Consultation Response from KC,
Streetscene

2022/93248 Piazza Centre, Princess Alexandra Walk, Huddersfield, HD1 2RS

Date Responded: 21/10/2022

Responding Ref: WPS 22-60

**Figure 5 Indicative Location of the Food Hall Waste Storage Area**

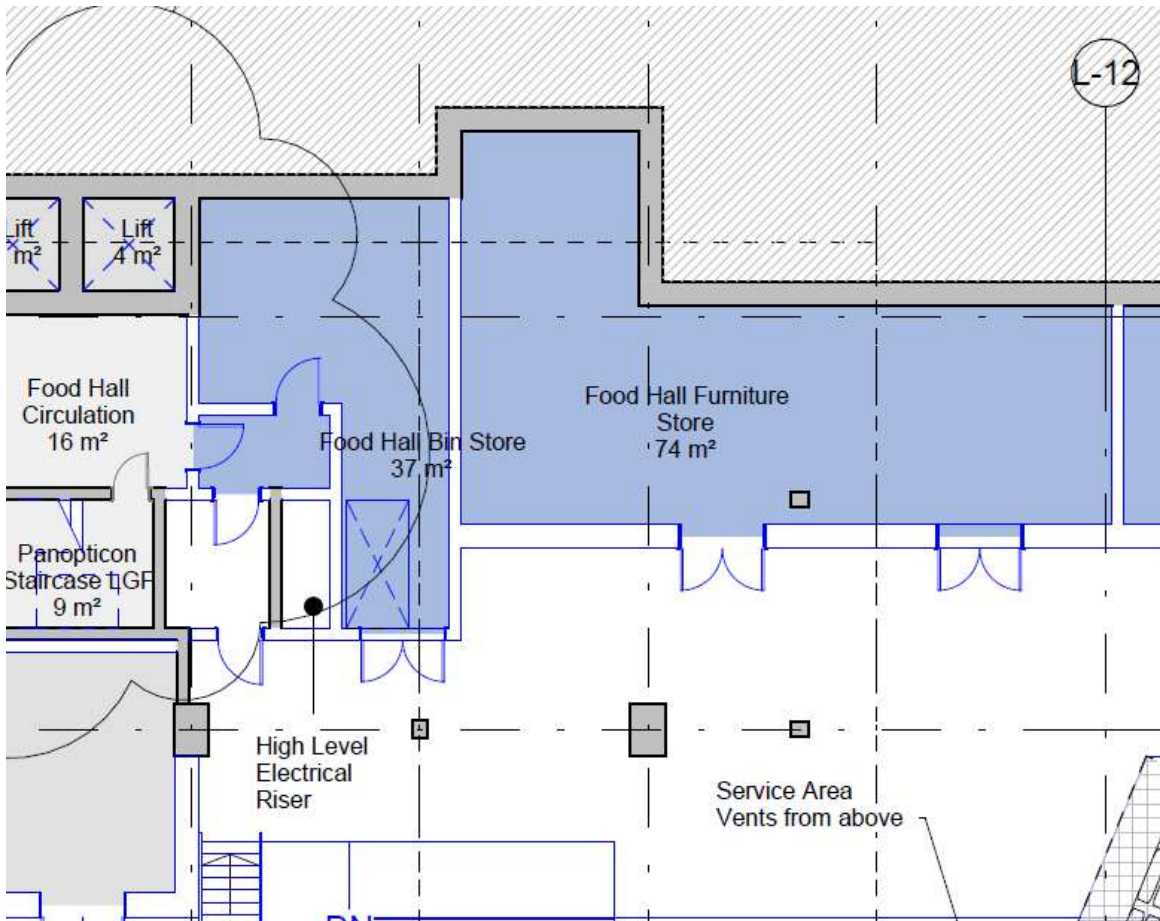
The Strategy has identified locations for waste storage within each sector of the development. Food hall Fig:5 page 23, Library Fig:6 page 24, Gallery Fig:7 page 25, Venue Fig:8 page 26, Museum Fig:9 page 27. The Multi Storey Car park and External venue is covered in Section 3.4.2.9 on page 27 There is also recognition of the need for some additional storage for occasional arisings, other wastes and WEEE/ Hazardous waste and this is outlined in 3.4.3 These stores appear to be big enough to accommodate anticipated arisings (although it is difficult to predict with any certainty other than being guided by the current baseline).

The design of the storage areas implies that waste will be collected and transported in 1100ltrs wheeliebins. The stores appear to be large enough to accommodate 1100ltrs bins with a mix of recycle and residual.

Clarification is sought as to whether bins will then be transferred to a Bin Collection Point where they will be loaded into a skip, compactor or direct to an RCV. If this is the case relevant information would need to be provided including: -

**Figure 8 Indicative Location of the Venue Waste Storage Areas**

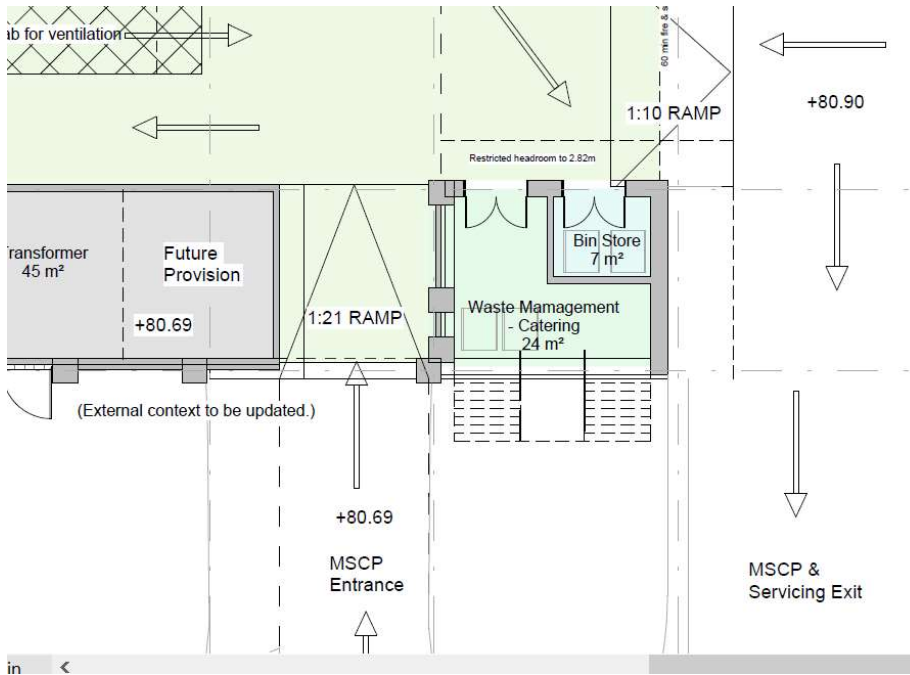
- Which elements of the development would consolidate waste (e.g., Library / Museum / Gallery / Food Hall) and whether The Venue waste would managed separately.
- Whether a facilities management company will be responsible for moving bins from storage locations to the consolidation/ BCP location or if there is an expectation with will be done by waste collection staff.
- What is the location of the consolidation/ BCP within the development.
